From: Amanda Scholes on behalf of Planning.Responses
Sent: 01 December 2021 08:39
To: Planning Scanning
Subject: FW: Dappers Lane - Drainage- OWC application - A/210/21/DOC

From: Laura Gibbons <[REDACTED]>
Sent: 30 November 2021 09:41
To: Anita Gardner <[REDACTED]>
Cc: Paul Cann <[REDACTED]>
Subject: RE: Dappers Lane - Drainage- OWC application

Condition 15

- A360-01C Drainage Strategy
- A360-02B Drainage Areas Plan
- A360-03A Surface Water Schedules

PERMEABLE BLOCK PAVED CAR PARK & DISTRIBUTION TANK DETAIL

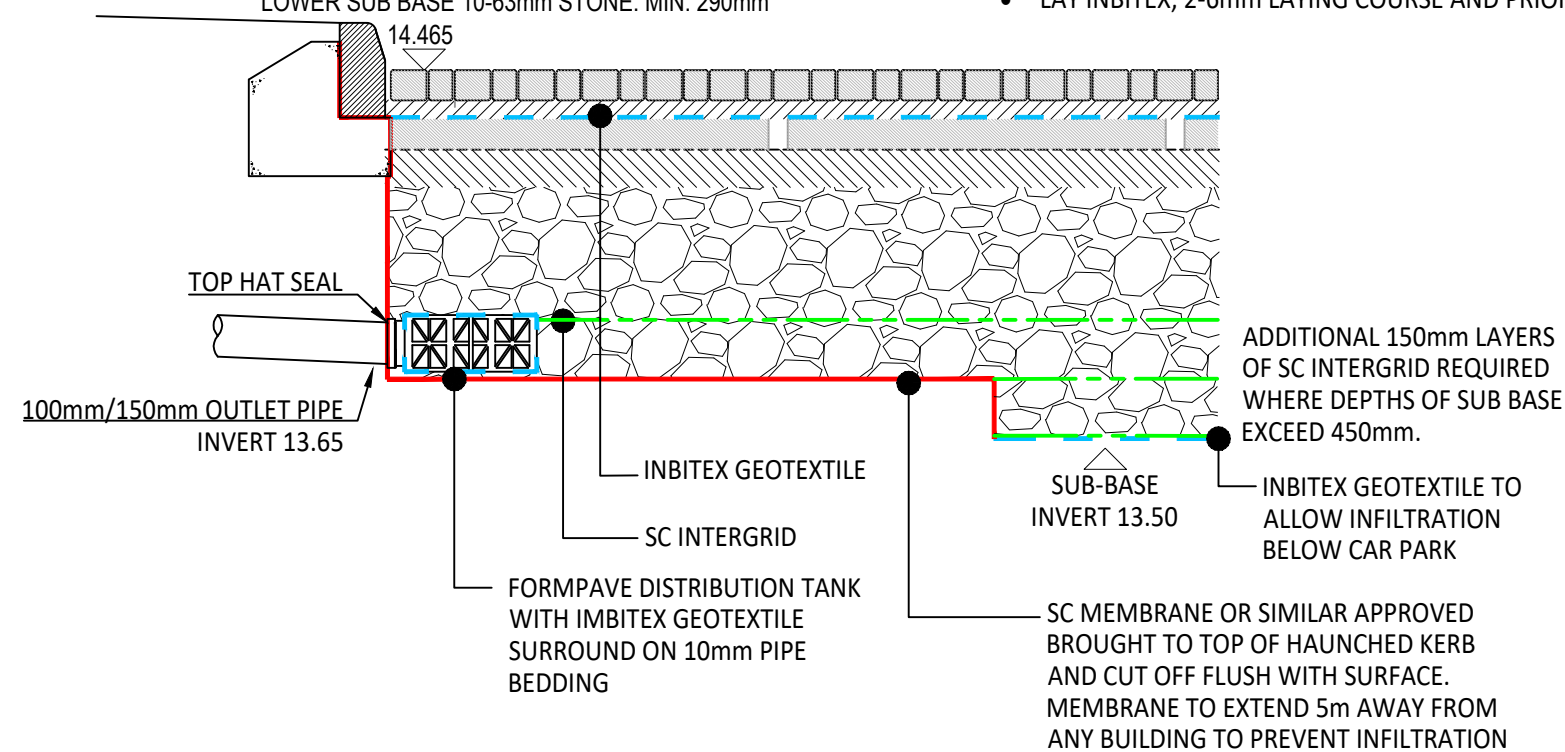
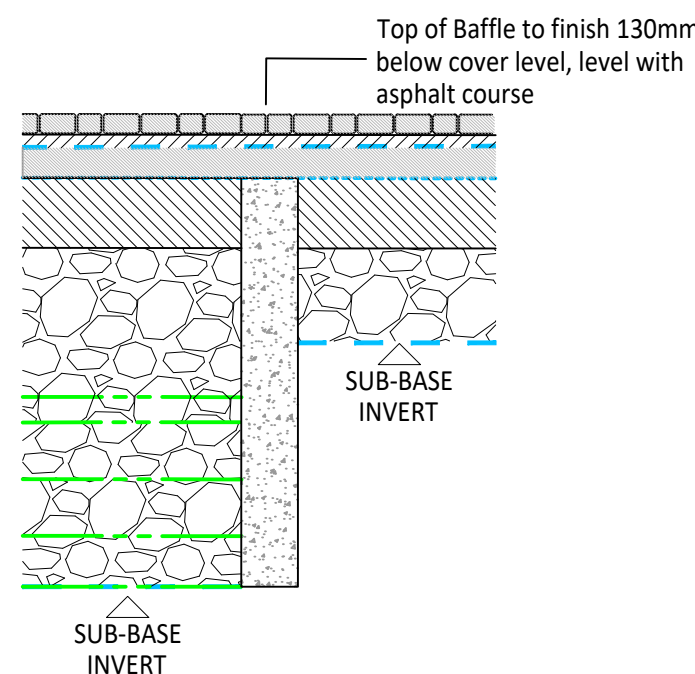
6. A construction detail drawing of the permeable paving is required. Including additional details showing diffuser block connections, and baffles. *Detail showing distribution tank does not appear to have been supplied. Awaited*

7. Please provide construction detail of permeable paving which is shown to not have a permeable sub-base. *Is this shown by the area with the SC membrane on the permeable block paved car park detail?*

ACO SWALE INLET DETAIL

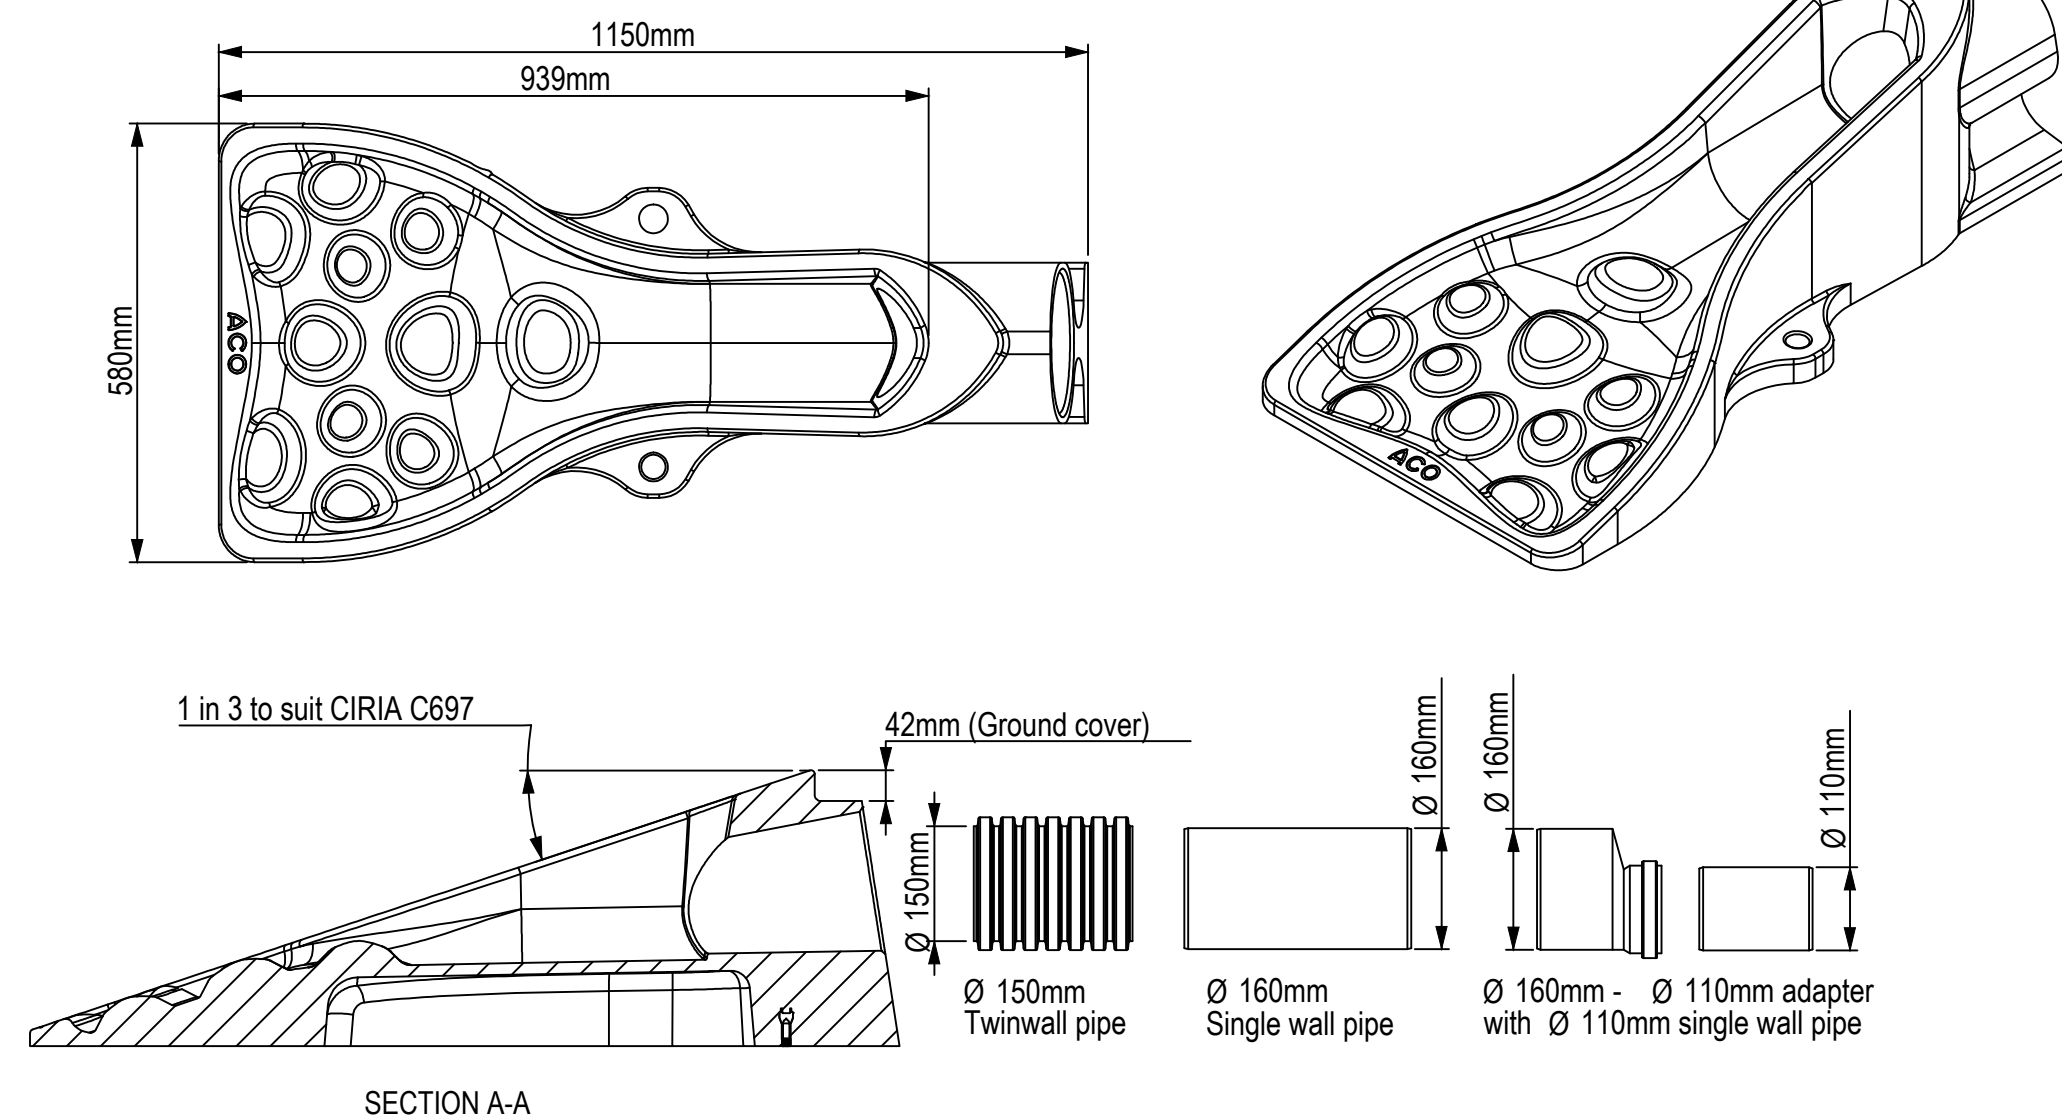
5. Please provide construction detail drawing showing swale cross section, long section, ACO inlet detail in relation to swale, connection between swale and ditch. *Await comments regarding proposed connection to ditch from a land drainage consent perspective.*

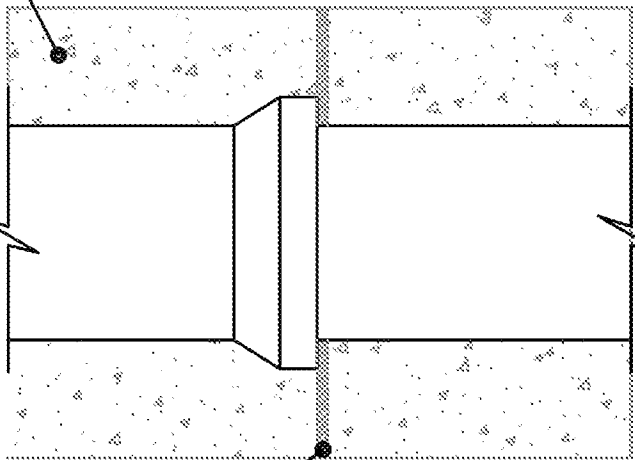
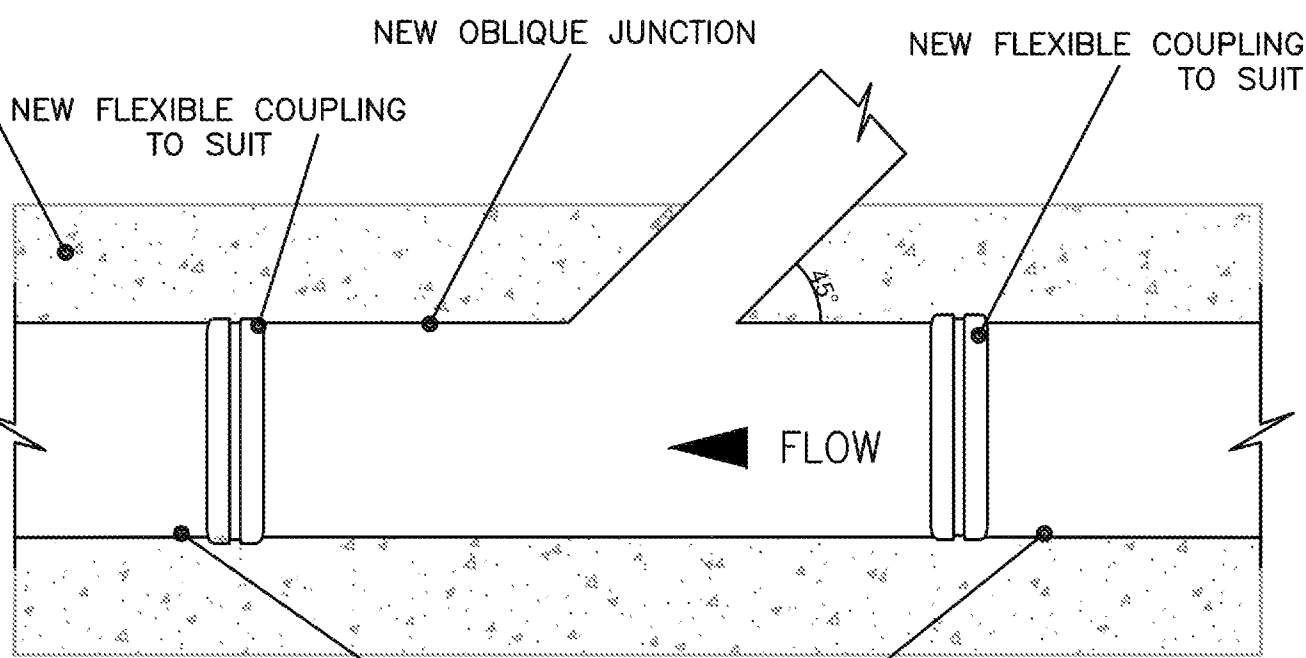
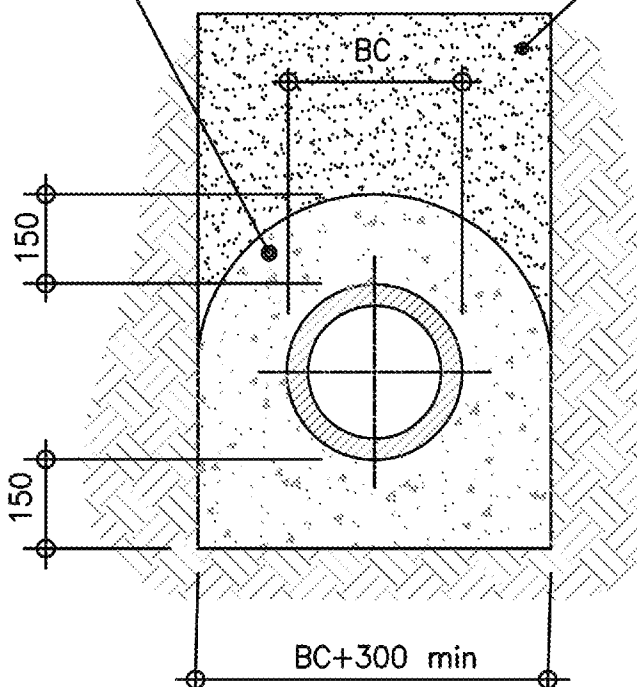
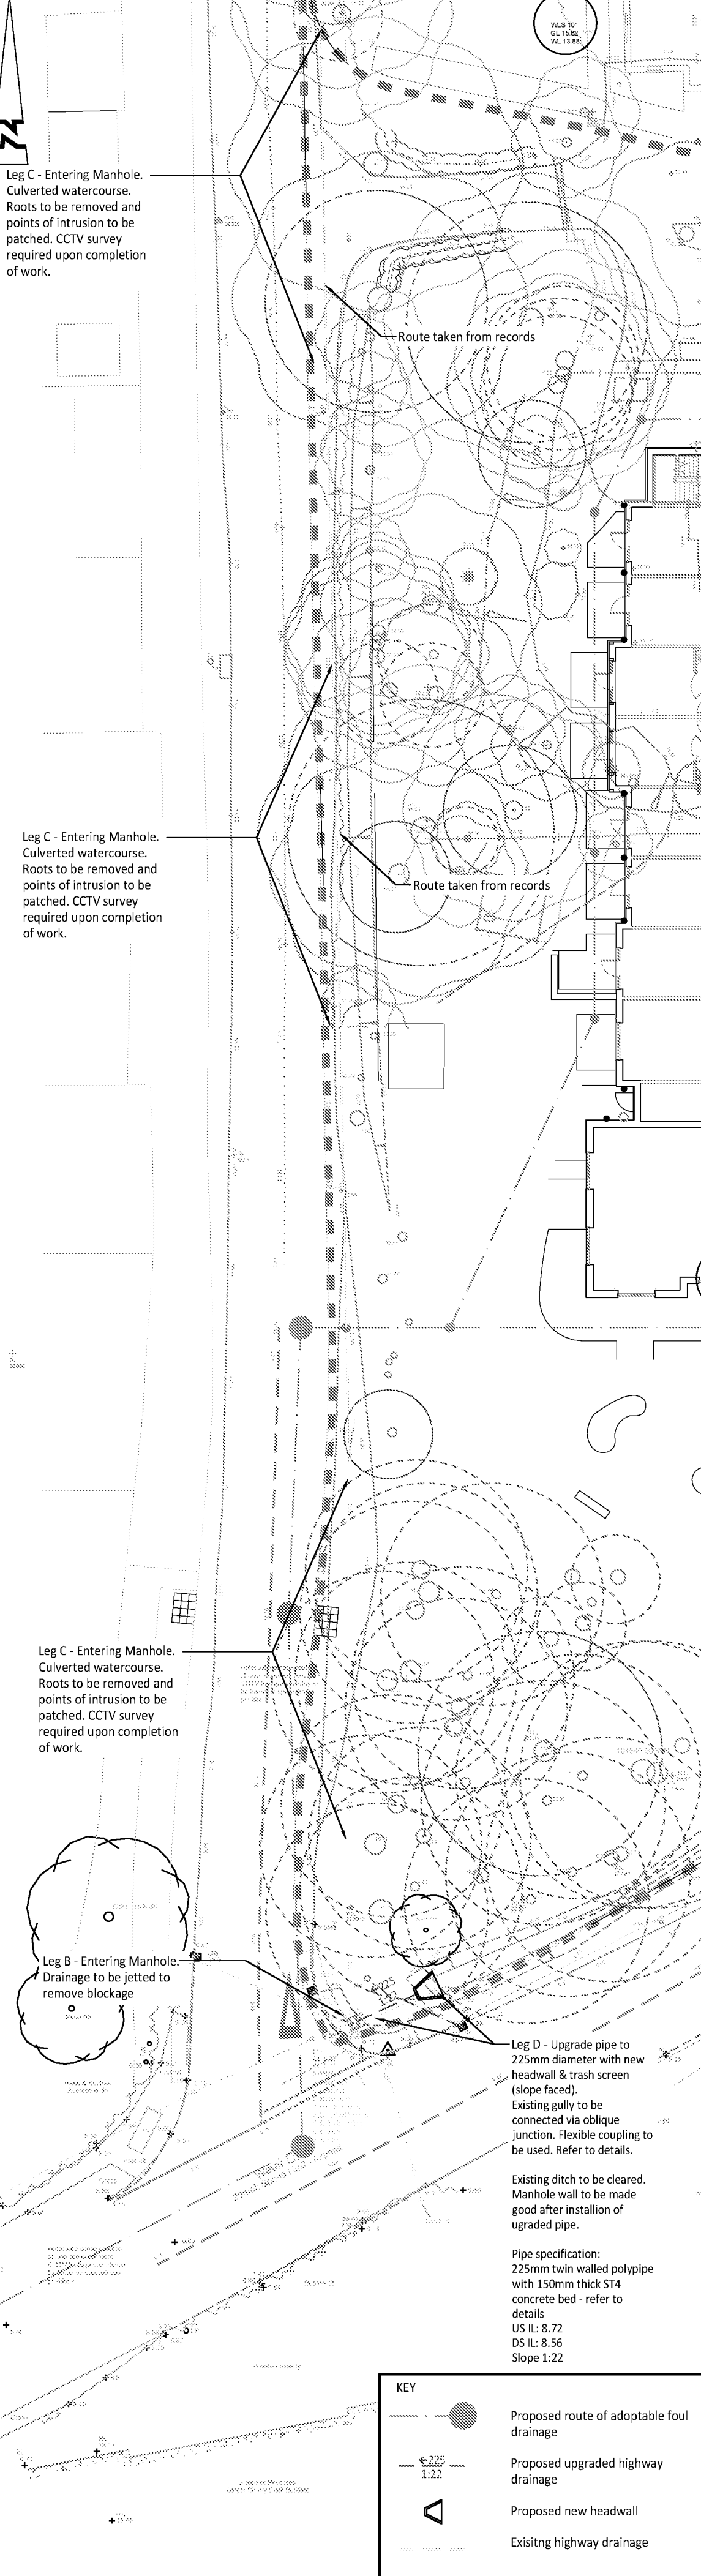
3. Please could you colour the culverts/ditch on the offsite drainage works plan to make them clearer. ok
4. Proposed headwall & Leg 'D';
 - a) Specify invert levels of proposed 225mm pipe. ok

- b) Brickwork refers to note 3 but should be note 2. Prefabricated headwall now specified as discussed. Specify the manufacturer and model, to suit the 225mm pipe.

- c) Show how the post & rail fence will be bolted to the headwall. Prefabricated hand railing now specified. ok
 - d) Please adjust the proposed trash screen design to utilise this one or very similar; 225mm Sloped Trash Screen with Sides 45 degrees | Althon Specify the 45 degree trash screen in association with 4b)

- e) Entry into existing manhole – make good manhole wall as necessary – add note. ok
 - f) All pipework to be twin walled polypipe or similar approved with 150mm thick ST4 concrete bed and surround with expansion joints. Add suitable note/detail. See enclosed drawing to assist.

5. Gully connection – existing lateral to be joined to new pipework/oblique junction using a 'flexible' coupling – add note. Remove the saddle connection detail as this is not applicable.

6. Leg 'B' - proposals noted thank you. -
7. Leg 'C' – proposals noted but ensure entire length of culvert adjacent the site boundary is shown. ok
8. Leg 'X' - Undertake further CCTV survey to enable completion of previous survey to Black Ditch – Present findings so further discussions can be had. Relevant notes added to plan. ok

9. Note 'Connection to be remade to upgraded pipeline between MH1 and ditch' shown in wrong location. ok
